# COUNTY COUNCIL'S RESPONSE TO CONSULTATION ON THE FOLLOWING DEVELOPMENT PROPOSAL

**Application no:19/01036/HYBRID**

**Proposal:** Development of a new Local Centre comprising Retail, Commercial and Community floorspace (flexible Use Class A1/A2/A3/B1/D1), and 38 residential units (use class C3) with associated access, servicing, landscaping and parking

**Location:** Bicester Eco Town Exemplar Site Phase 2 Charlotte Avenue Bicester

# APPENDIX A – Proposed Site Layout

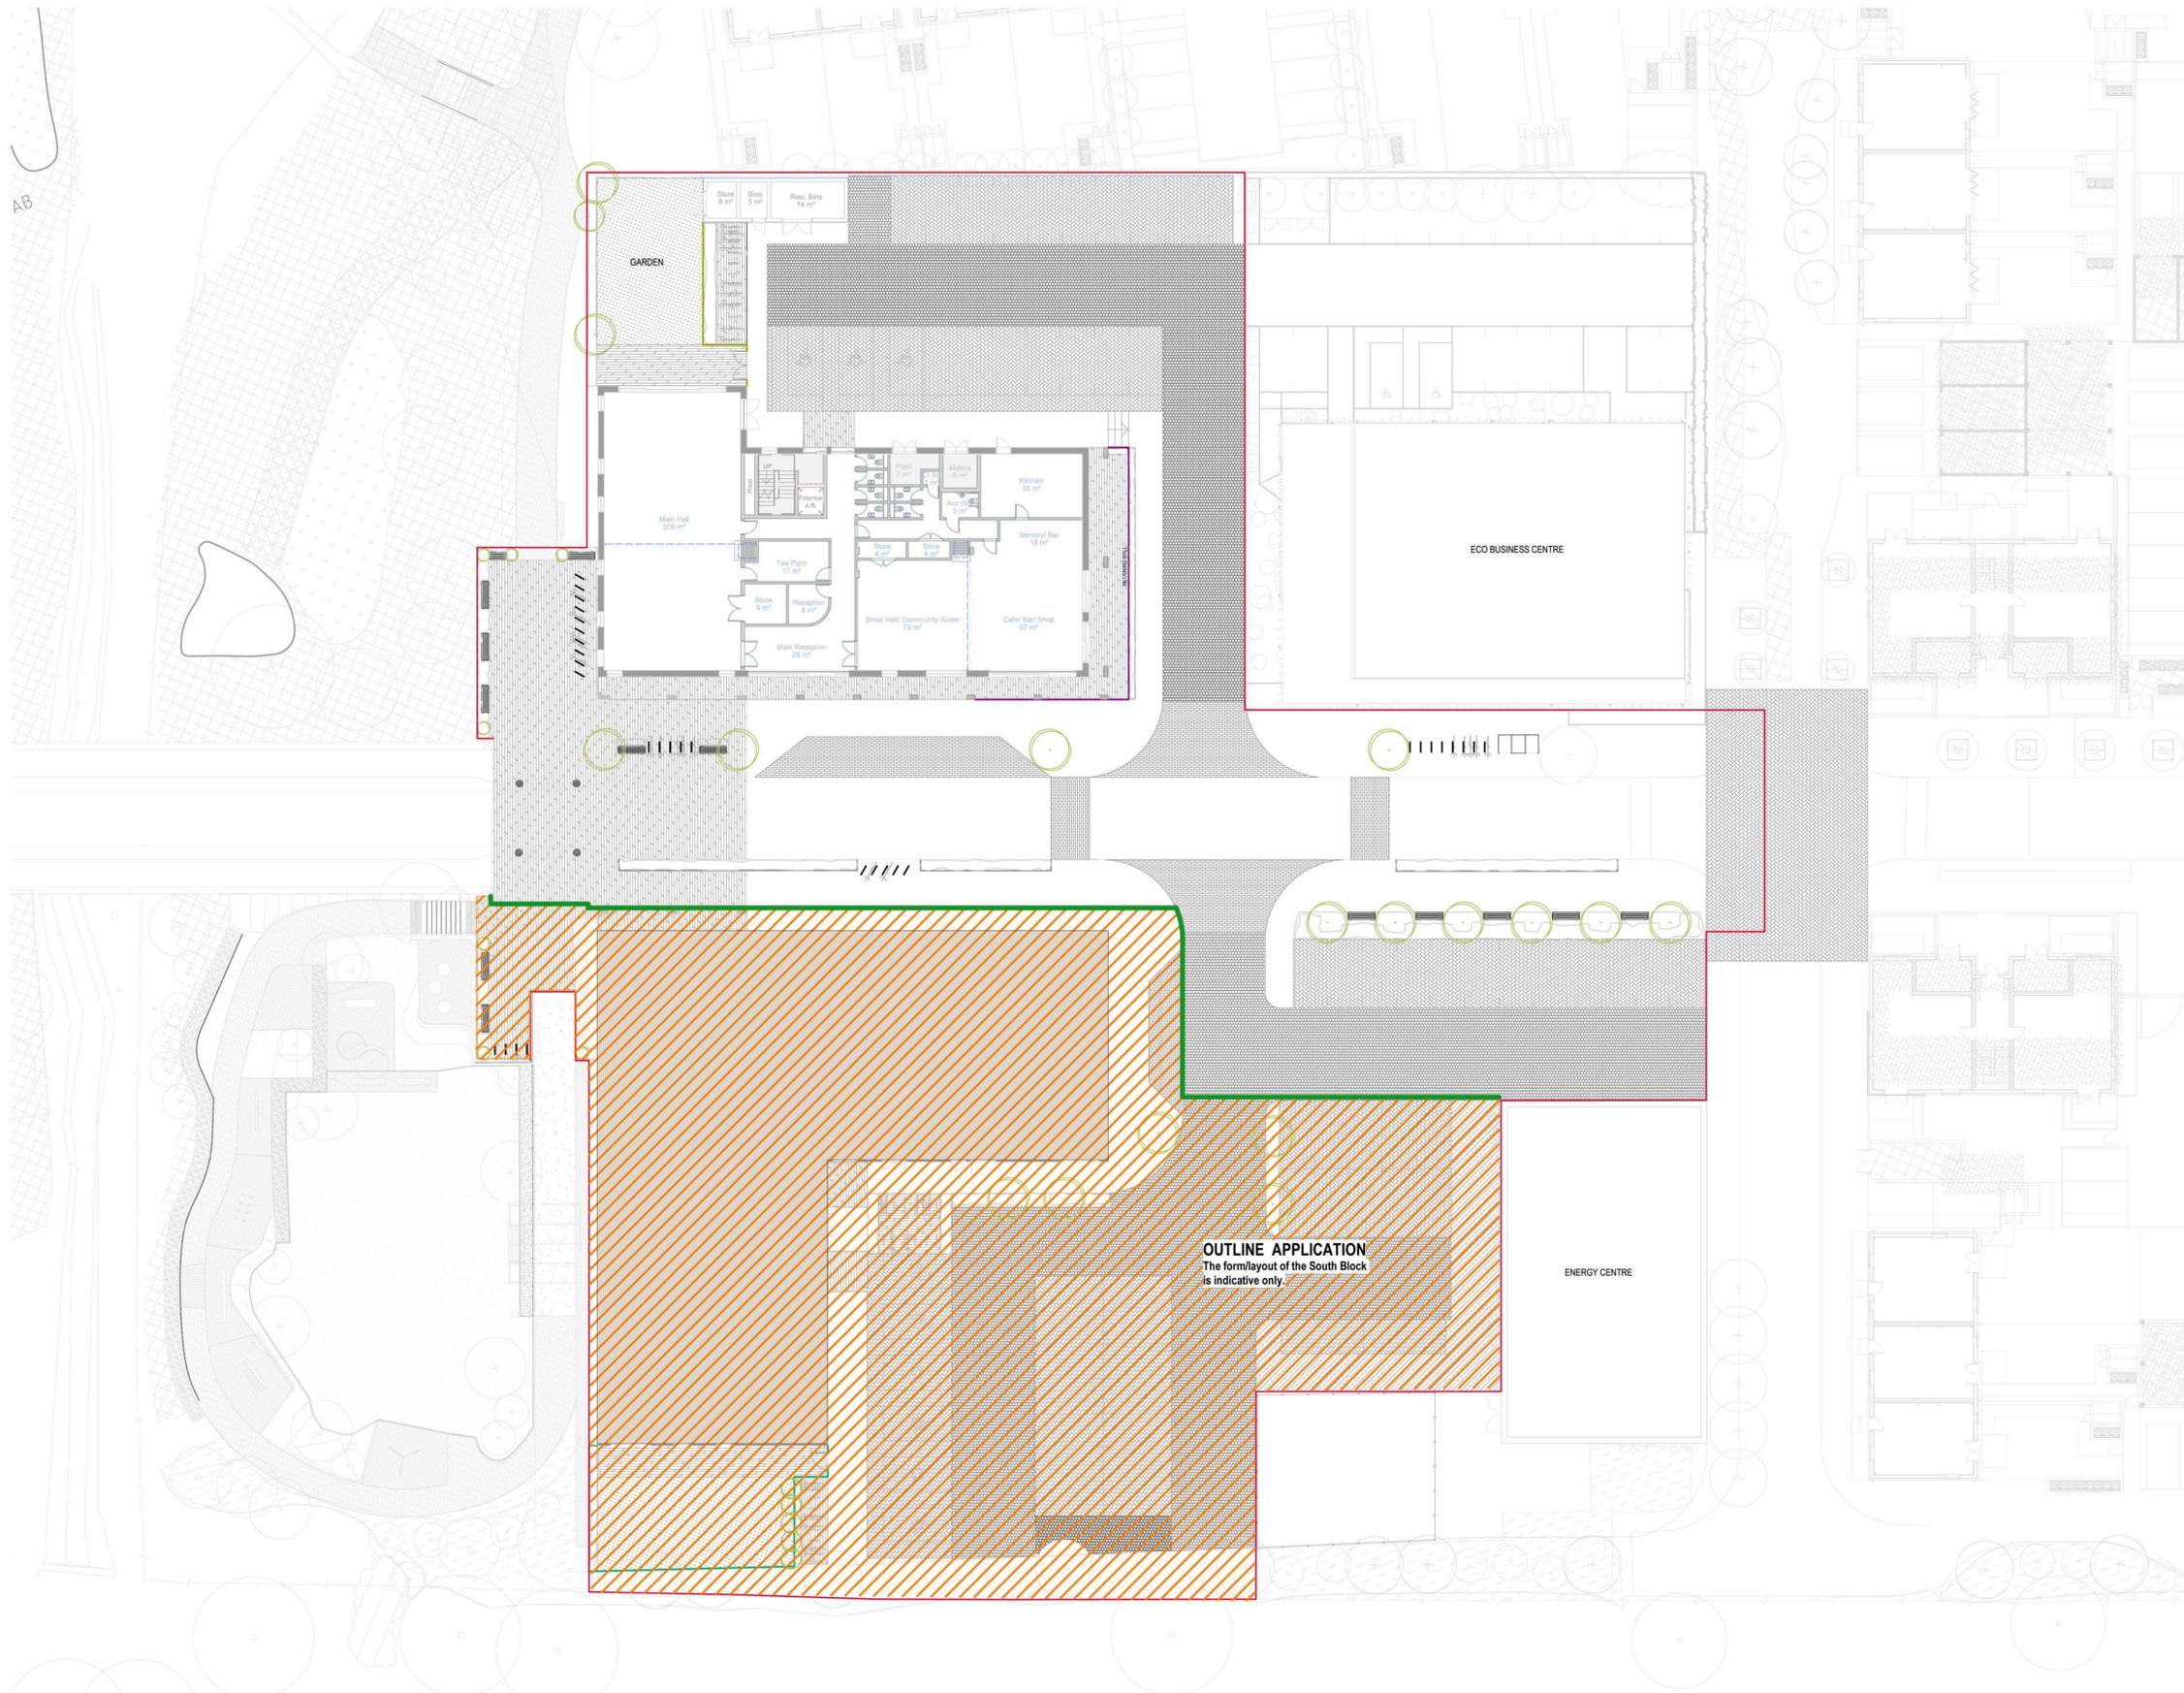
Vehicle Tracking – Tracking diagrams have been provided for the site layout showing that an 11.7m refuse vehicle would be able to manoeuvre in and out of the site. However, I do not believe that the refuse vehicle can safely get to within the

recommended distance to service the bin storage located to the top left corner of the site.

To accomplish the refuse collection task, the refuse wagon needs to utilise land (outside of the red application line) north of the Eco Business Centre in order to reverse towards the bin storage area (see snippet below). Similarly, I believe egress shall be harder to achieve except by blindly reversing back onto Charlotte Avenue, a manoeuvre deemed to be unsafe for all users.

A confirmatory letter of agreement between the developer of this site and the land owner of the Eco Business Centre to use this area (outside the site application boundary) in order to achieve such manoeuvres has since been provided. Without this perpetual agreement, refuse and service deliveries to the local centre would be impossible.
